<b>Location of Construction:</b> 157 York St	<b>Owner Name:</b> Barker Wayne	34 Park St	775-1892
	Applicant	<b>Contractor Address:</b> 34 Park Street Portland	2077751892
<b>Lessee/Buyer's Name</b>		Multi Family	<b>Zone:</b>

**Dept:** Zoning      **Status:** Approved with Conditions      **Reviewer:** Marge Schmuckal      **Approval Date:** 07/14/2004

**Dept:** Fire      **Status:** Approved with Conditions      **Reviewer:** Lt. MacDougal      **Approval Date:** 07/19/2004

A-11

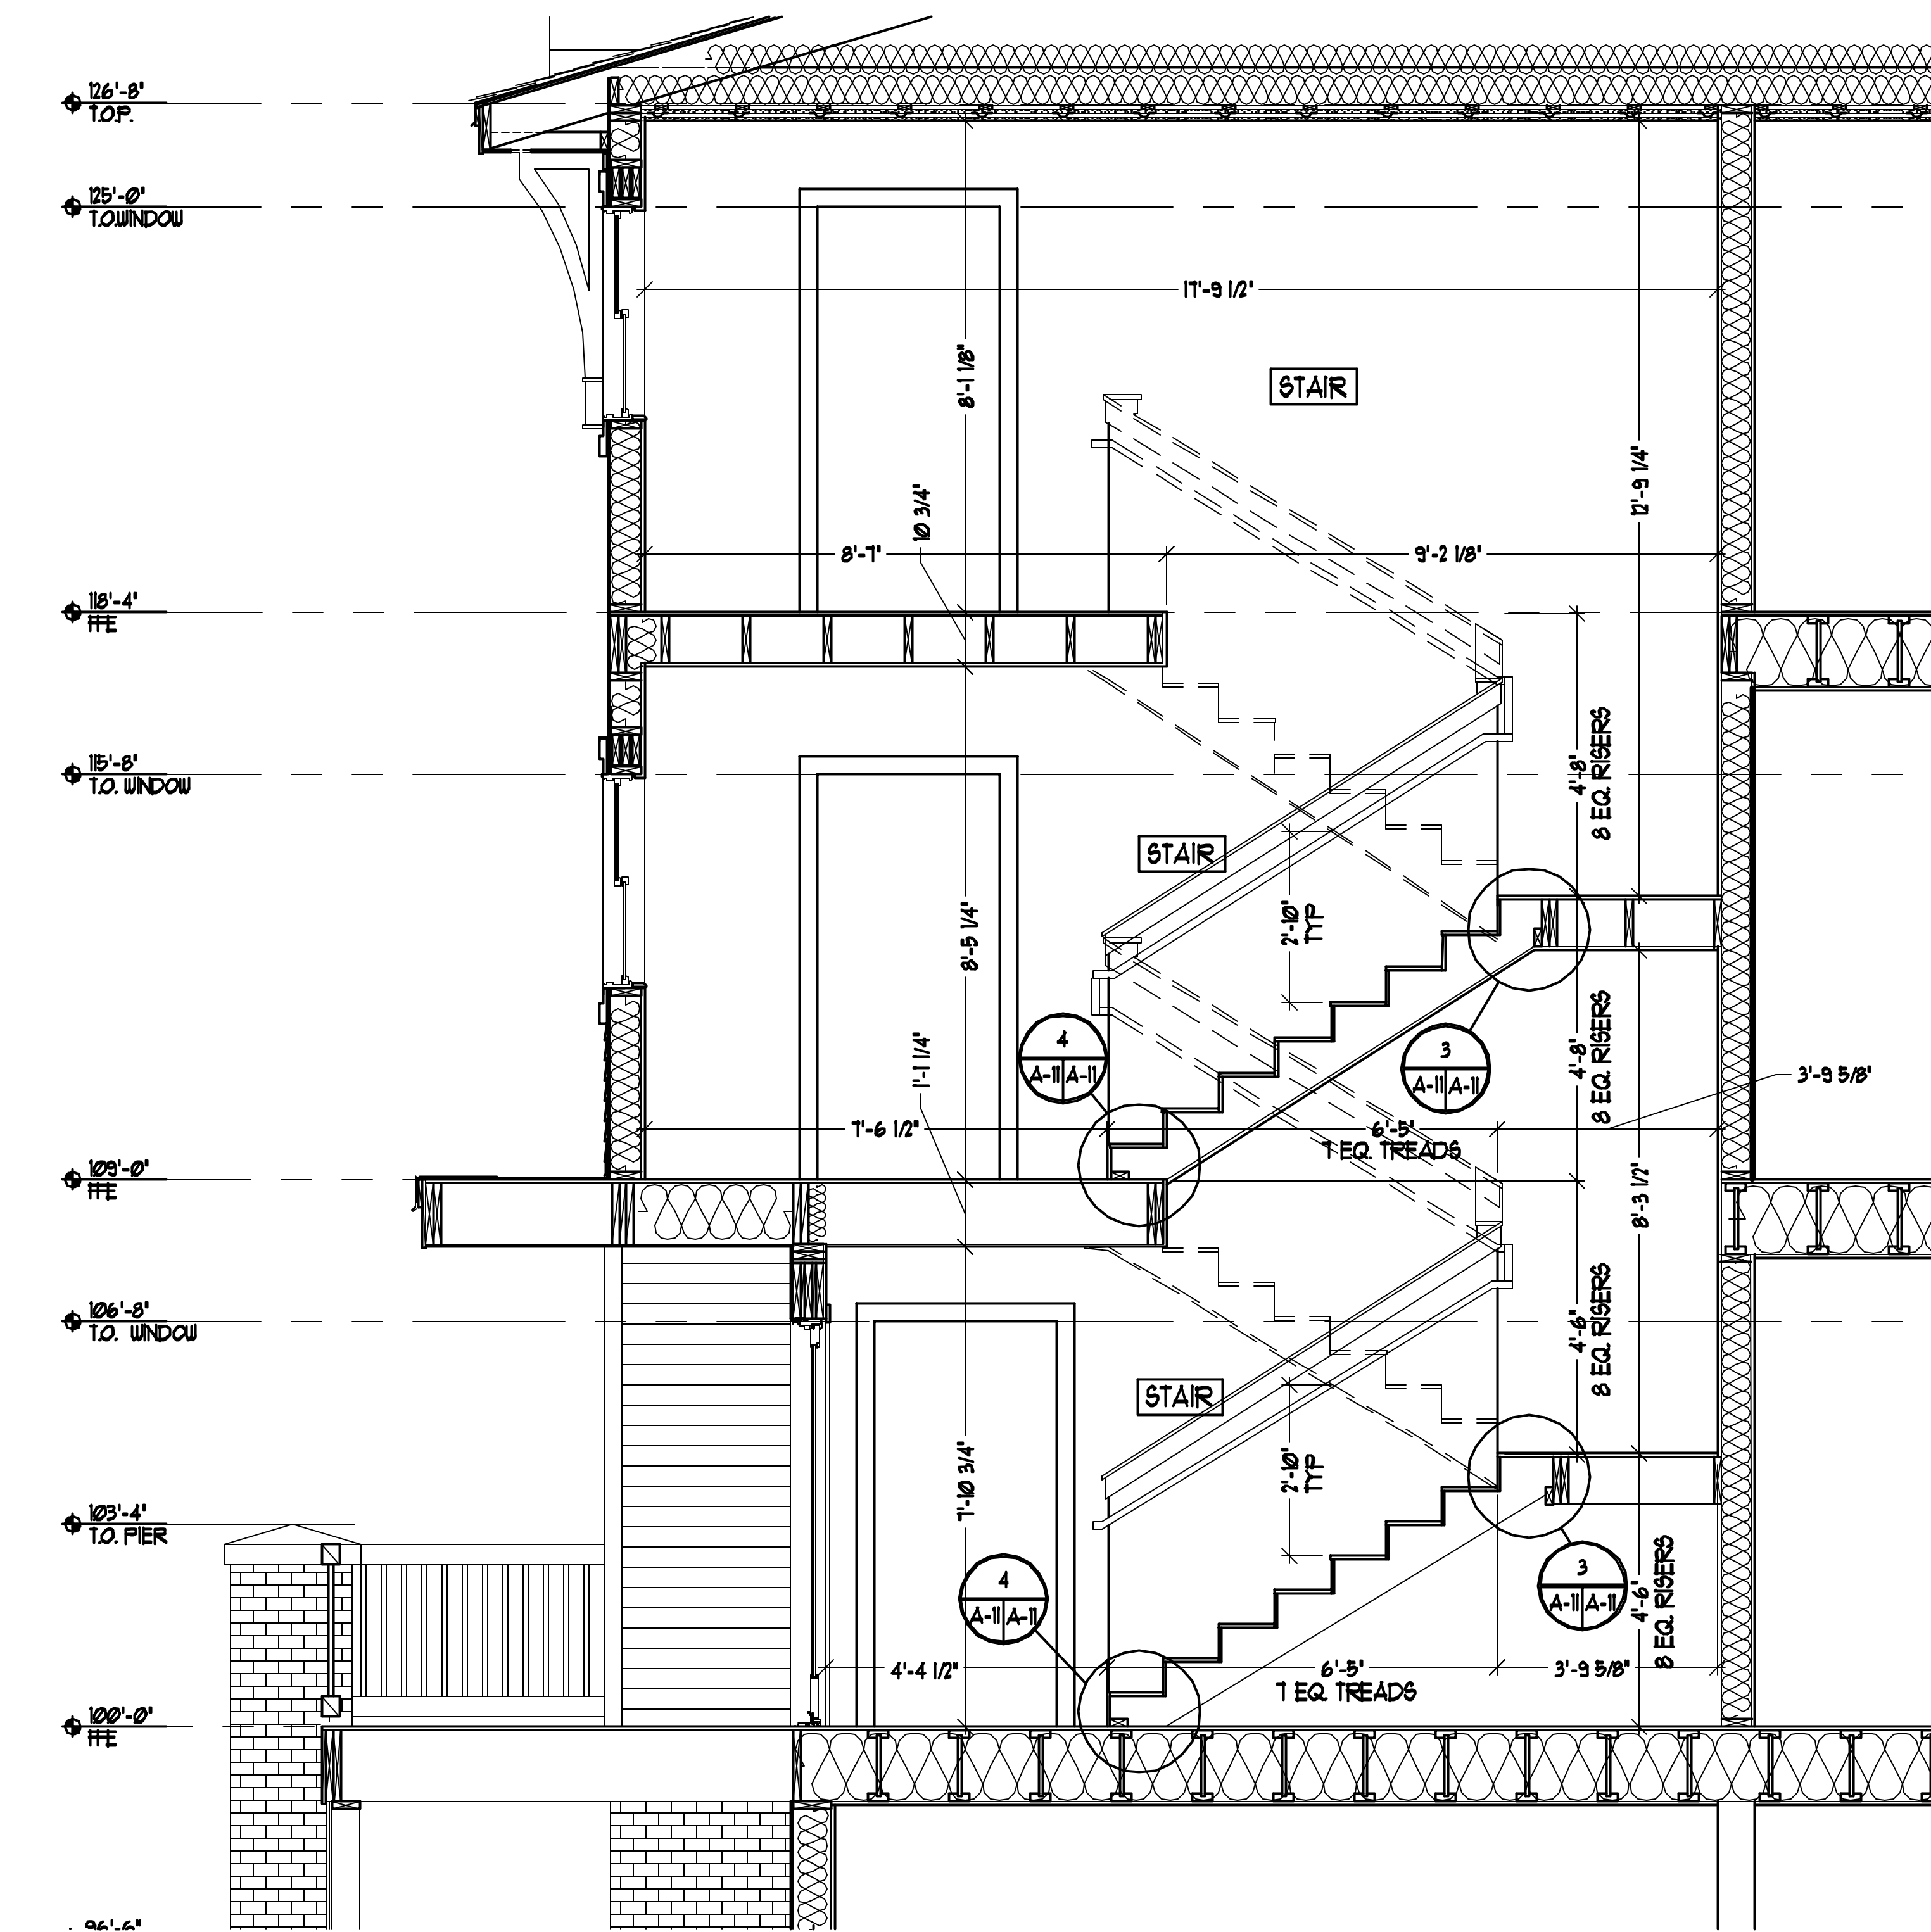
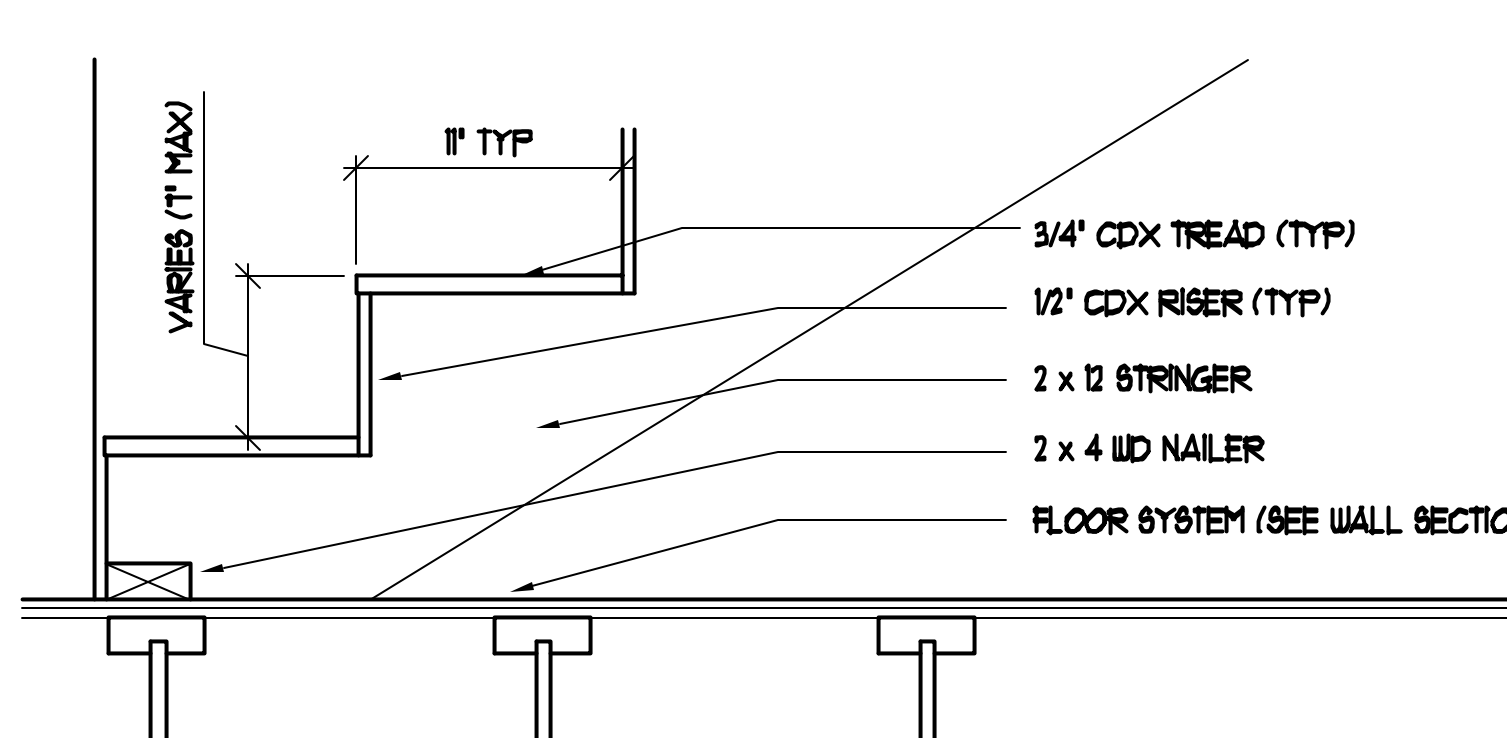
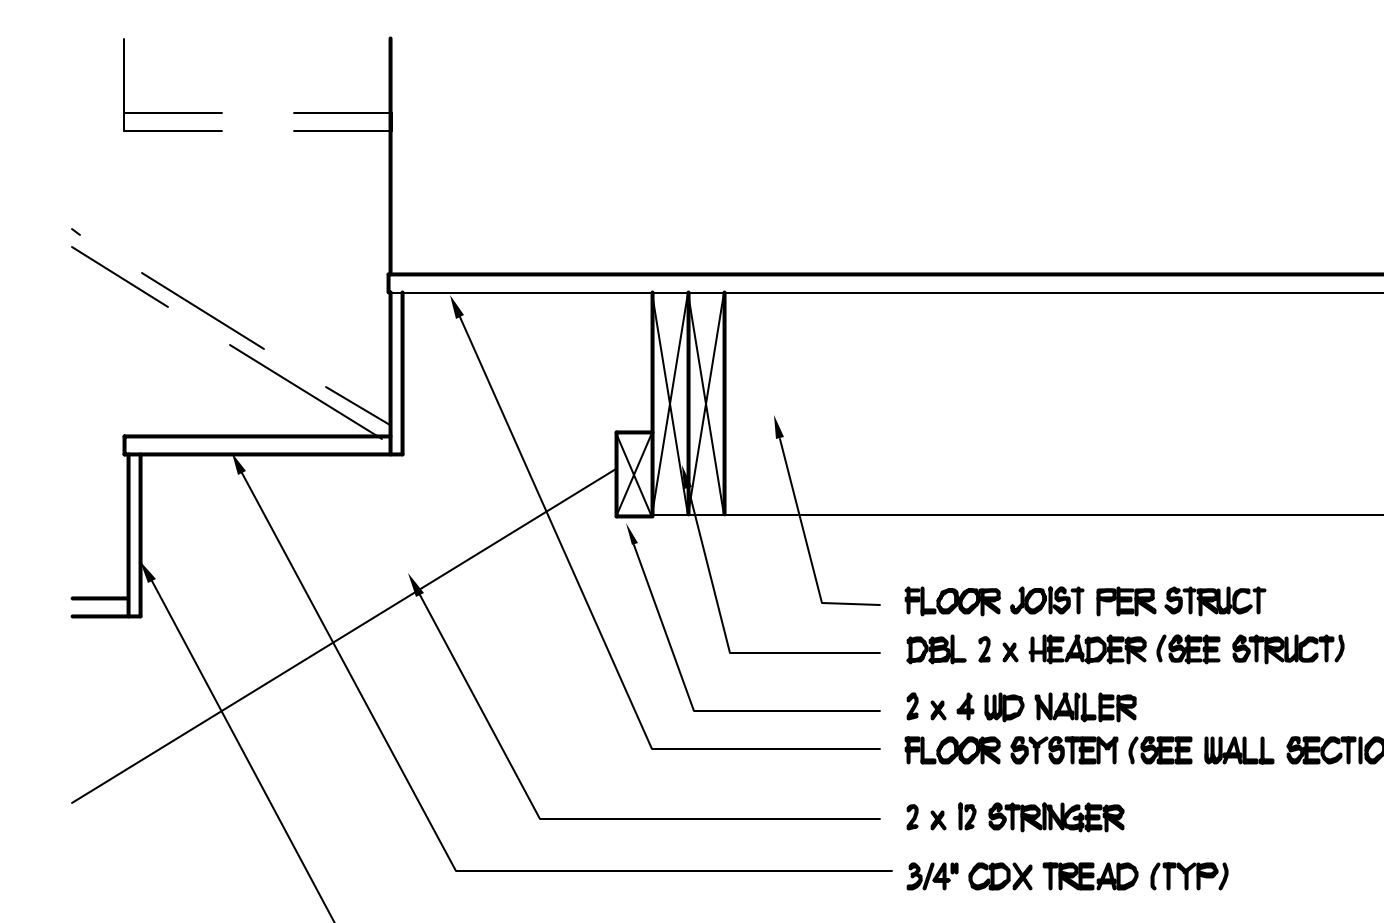
- 1) Guards shall be a minimum of 42" in height
- 2) smoke detectors shall be installed in accordance with NFPA 101, Life Safety Code
- 3) stairs shall have no projecting edge
- 4) stairs shall be 7" maximum riser & 11" minimum tread
- 5) exits shall have a minimum of One hour rating ( doors are now 45 min )
